# DRB CASE ACTION LOG

DRB Application No.: 03DRB-00179 (SBP)  
Project Name: **KEITH APARTMENTS**  
Agent: HEWITT ENGINEERING & ENVIRON.

Project # **1002332**  
EPC Application No: 02EPC-01690/01692/01694  
Phone No.: **220-7537**

SITE PLAN

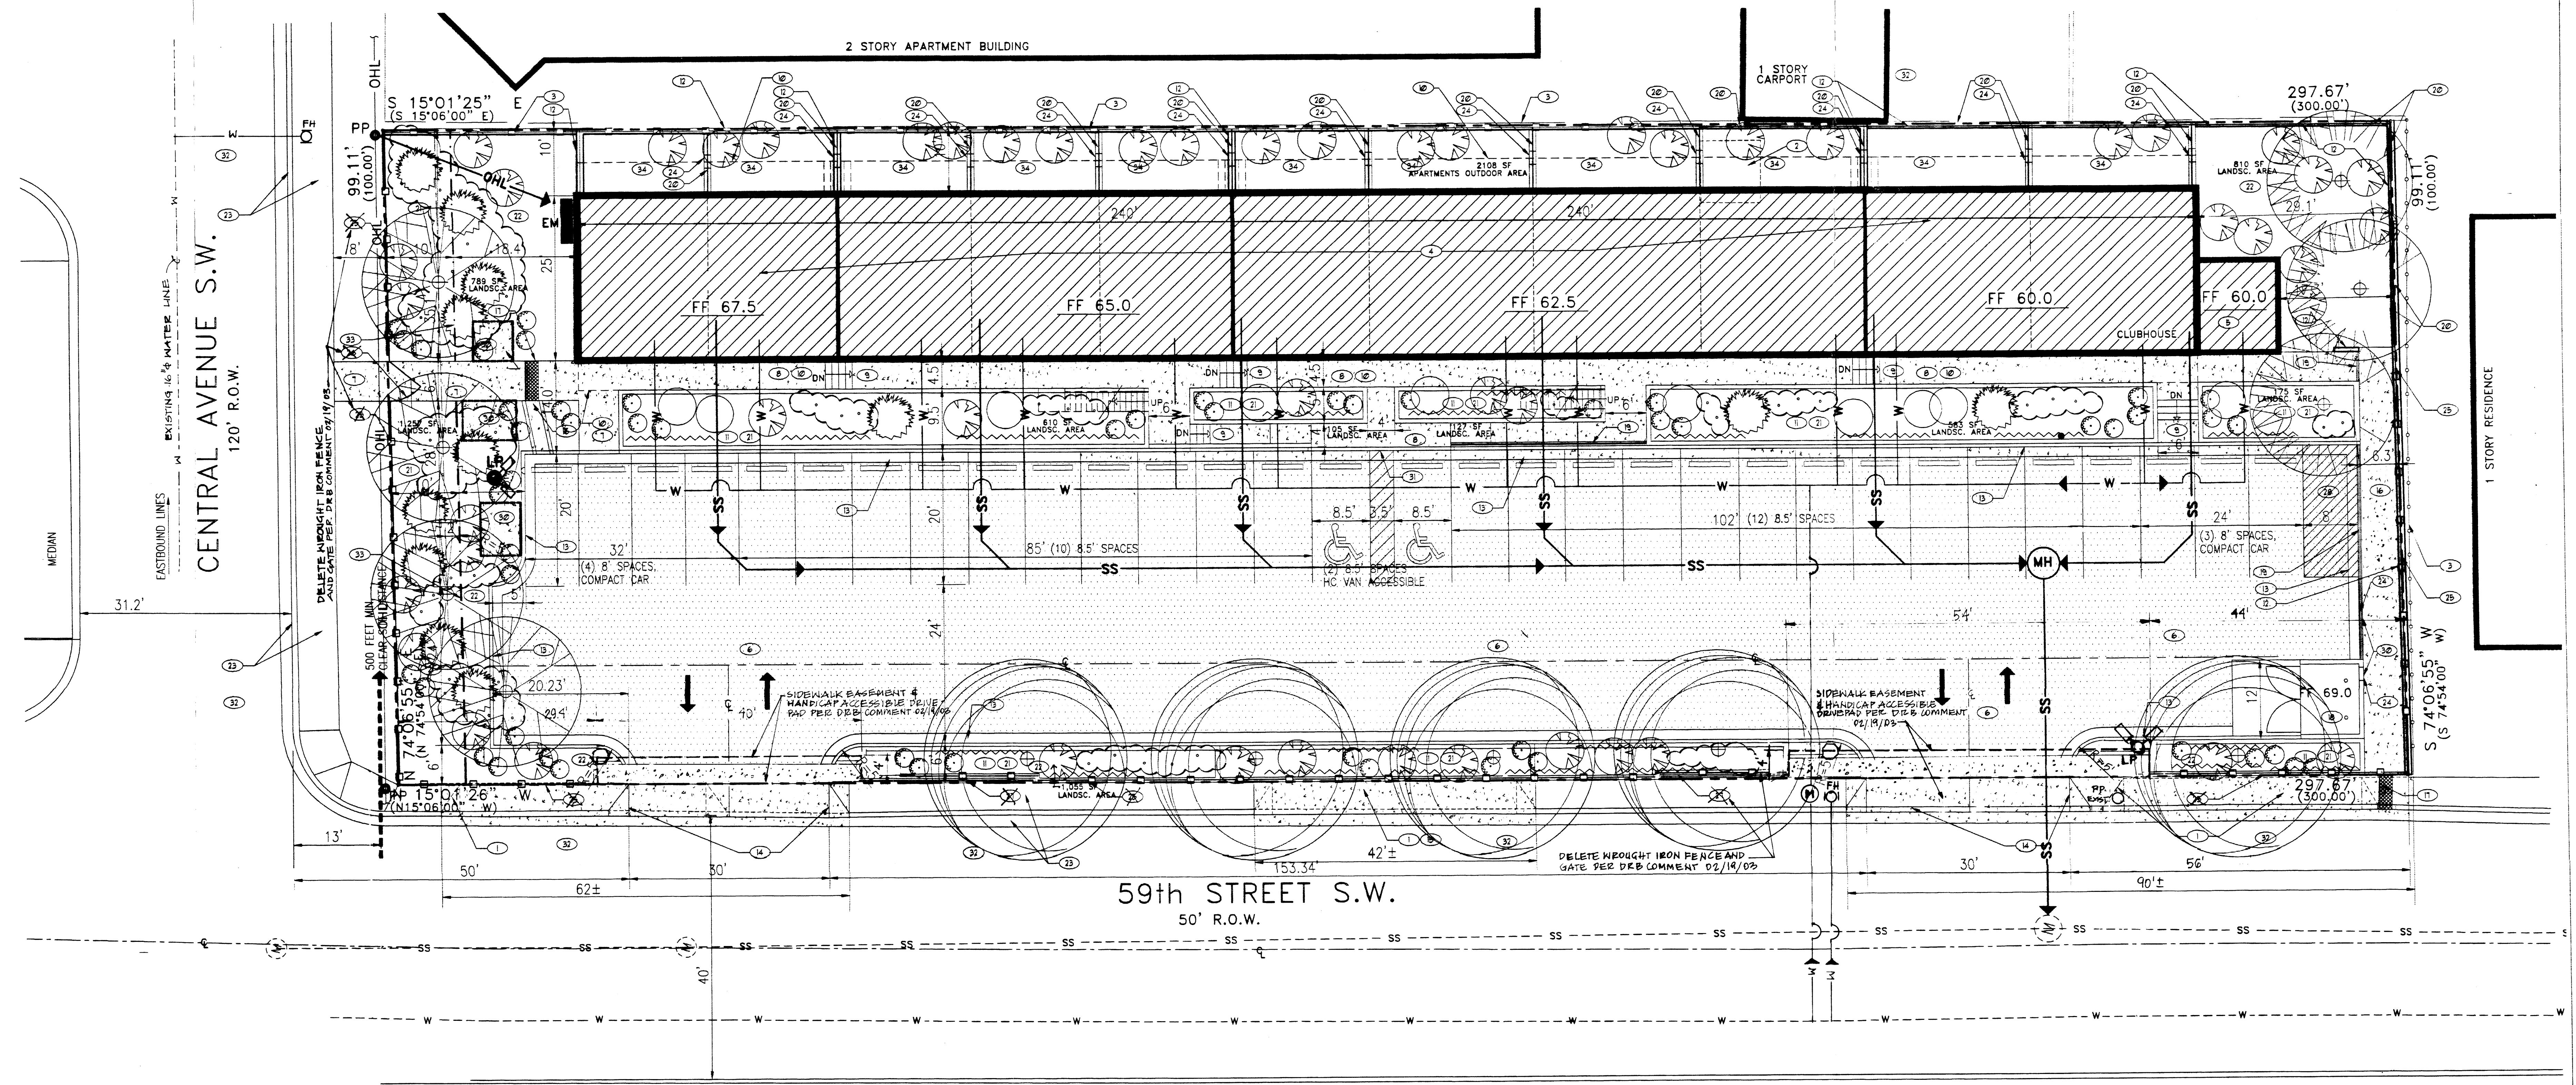
TRANSPORTATION: 200 Ft. of visibility needs to be provided on 59th Street at entrances  
 - H.C. Accessible DRIVEPADS

No.	Comment
<input type="checkbox"/>	Access out of the site and handicap accessible drivepads needs to be demonstrated.
